Your Ref: OWPC4000
Our Ref: AB/115/14/OUT 17-09-2014
Please ask for:
Mr D Sullivan

Outline application with some matters reserved for 2No. 3 bed semi detached houses
12 & 14 Canada Road Arundel

Thank you for your internet representation made on 7th October 2014 which has been recorded as **an objection** with the comments as follows:

Drg Title: SITE PLAN		Drg No: 14/1950/S01
Client:	Location:	Rev: A
MR SCODFREY	12-14 CANADA ROAD	Scale: 1:200 (A3)
	ARUNDEL	Drawn by: JSW

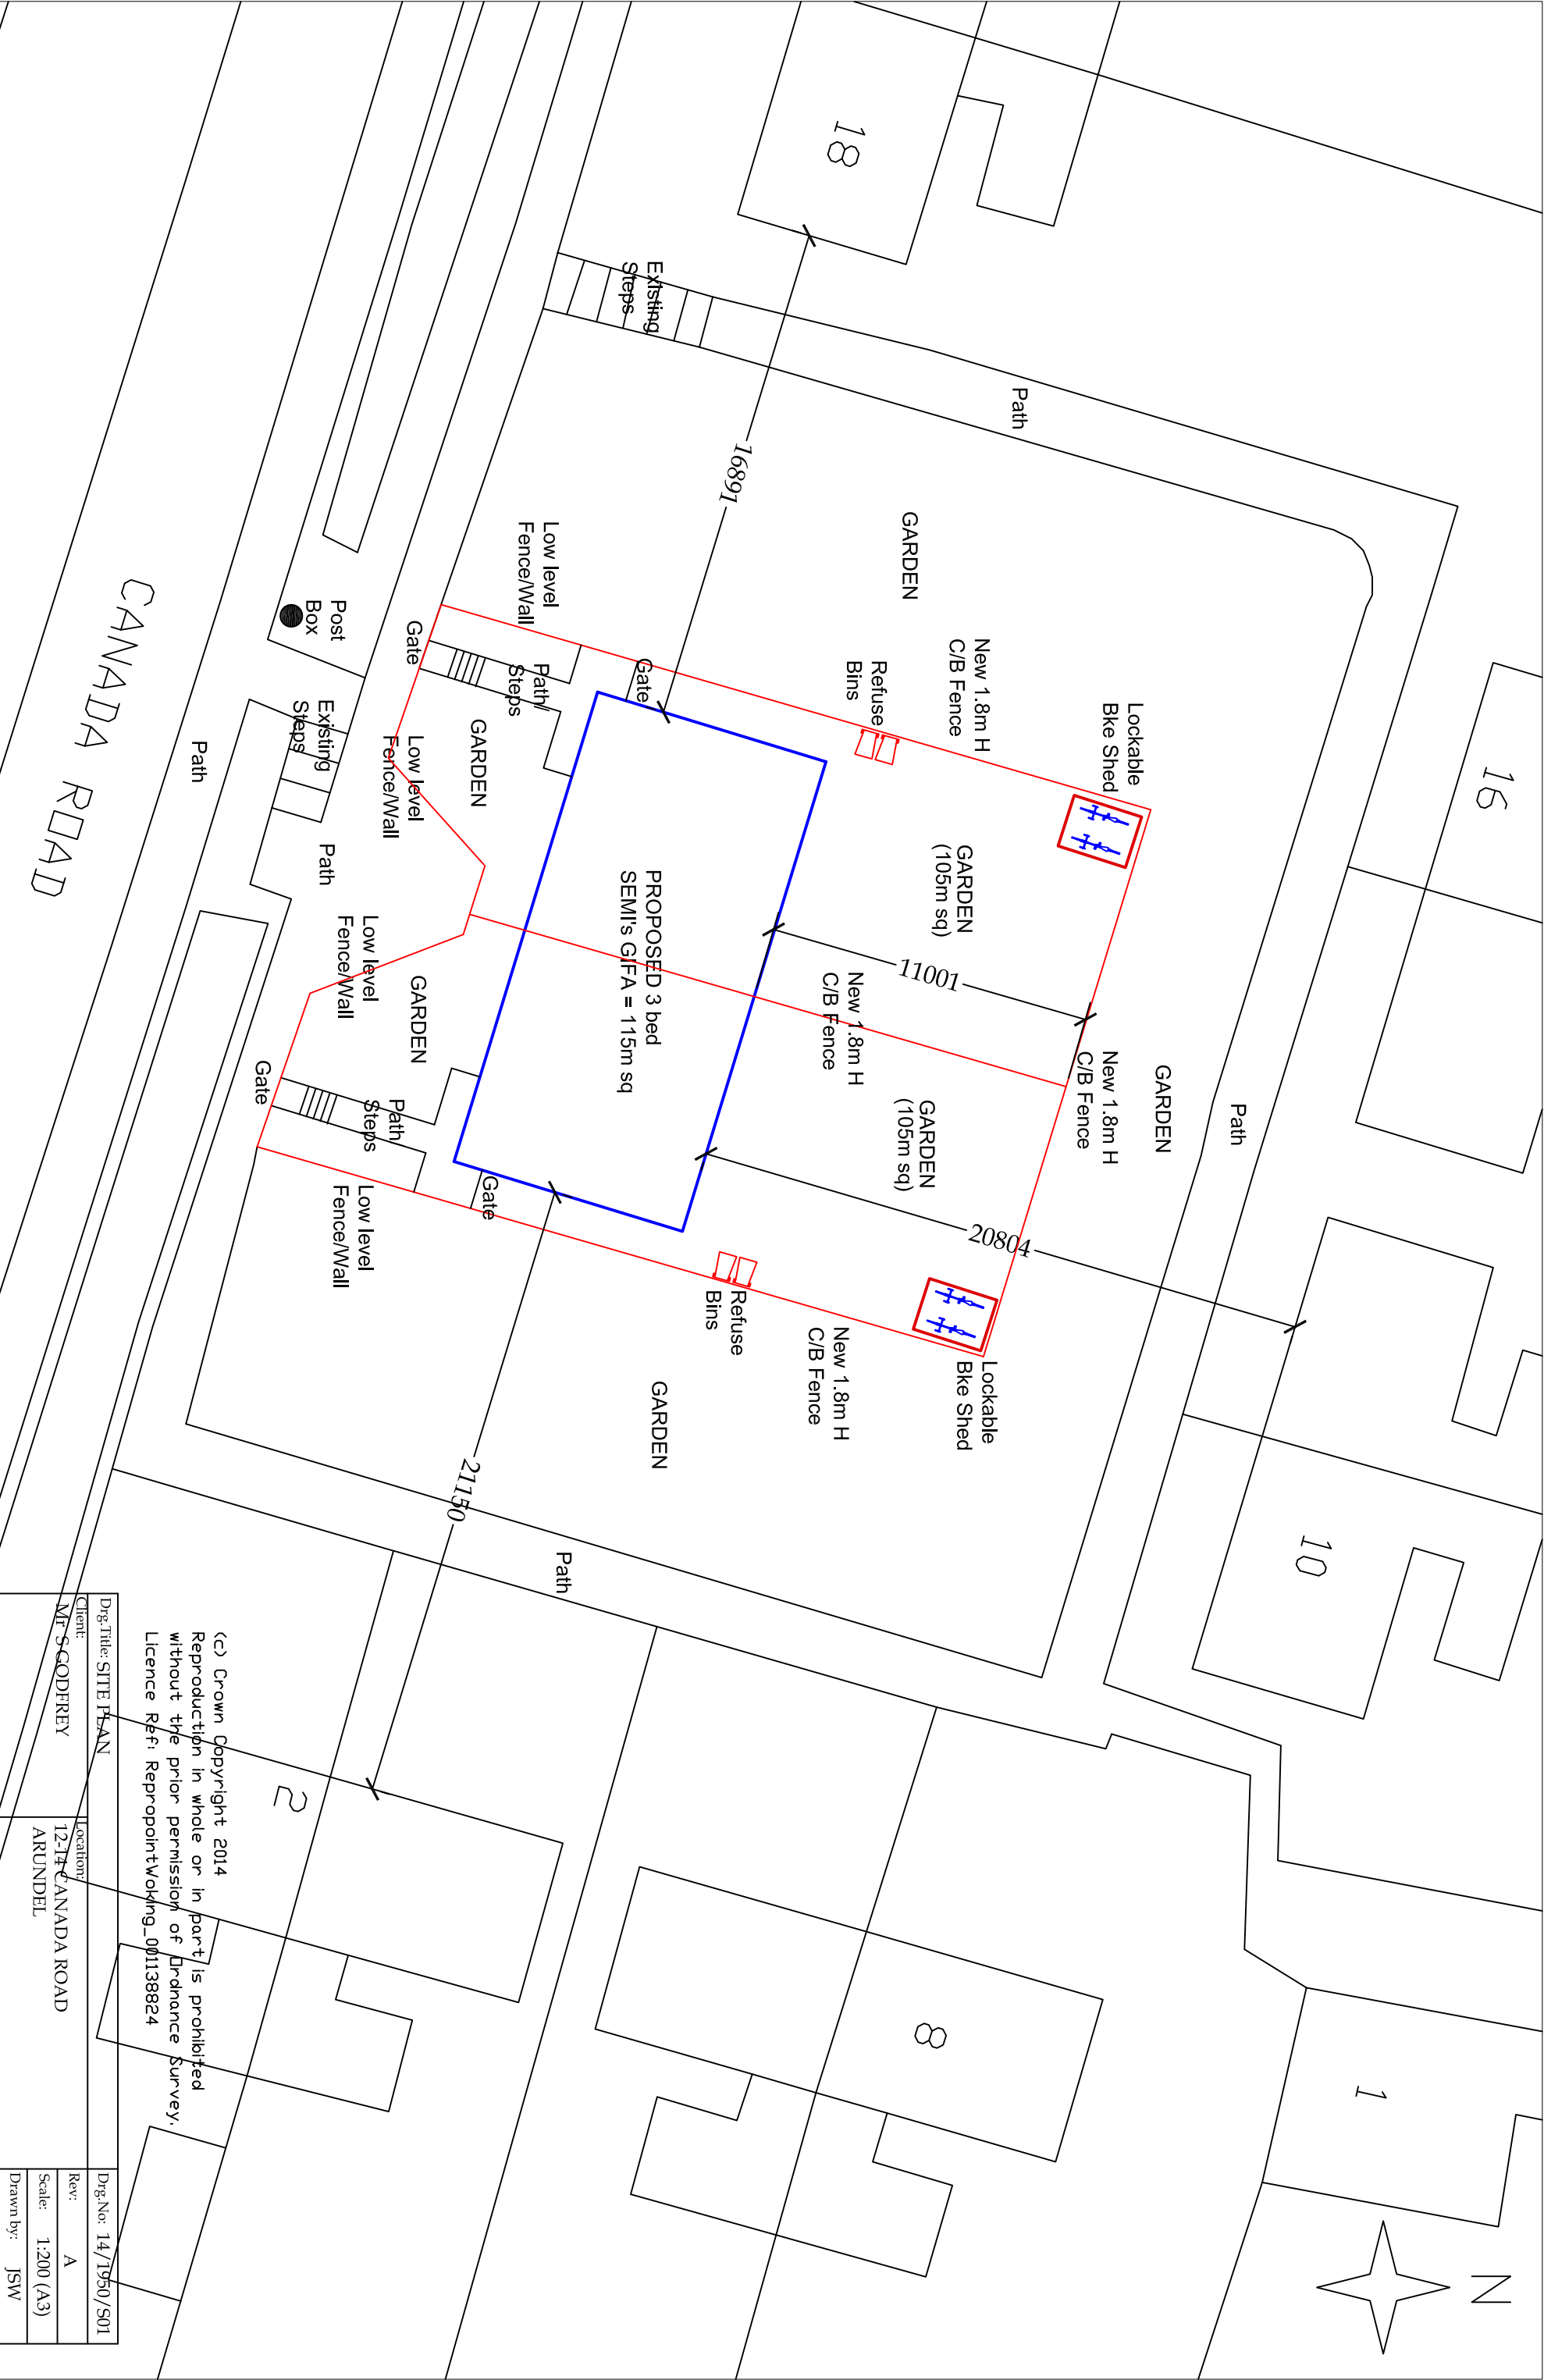
I object to the plans for housing in Canada Road. Firstly you say the buildings will have obscure glass at the windows were they overlook properties, they are overlooked by properties on three sides, will they have obscured glass all around? I don't suppose they will so someone will be overlooked by them.

Secondly you say the property is on a slope so this will reduce it imposing on other residences, it is actually at the same height as my house so it will impinge on my view. The poly tunnel at no 12 was put up and is now hidden by a monstrous hedge which takes most of our light, a house will be even taller and will reduce the level of light - which is poor already.

You say the houses will have a fence around them 6ft high, all the surrounding properties (exc 12) have stuck to the deeds which says the properties gardens should be open plan, why are these properties an exception to this, why are they not open plan too, why isn't number 12?

The parking survey was completed in the day and at five o'clock, when most people who work come in after five. After five there are no spaces in the road and in the winter the land next to the park is so muddy it renders it practically unusable. so the new properties will probably park on the busy road.

There is no restriction on people planting trees etc in the gardens of these properties and we have all had to suffer light reduction due to the excessive growth of shrubs outside the property at no 12, If the residents of the new properties have bamboo as tall as their houses or trees we will have no redress for this later on.
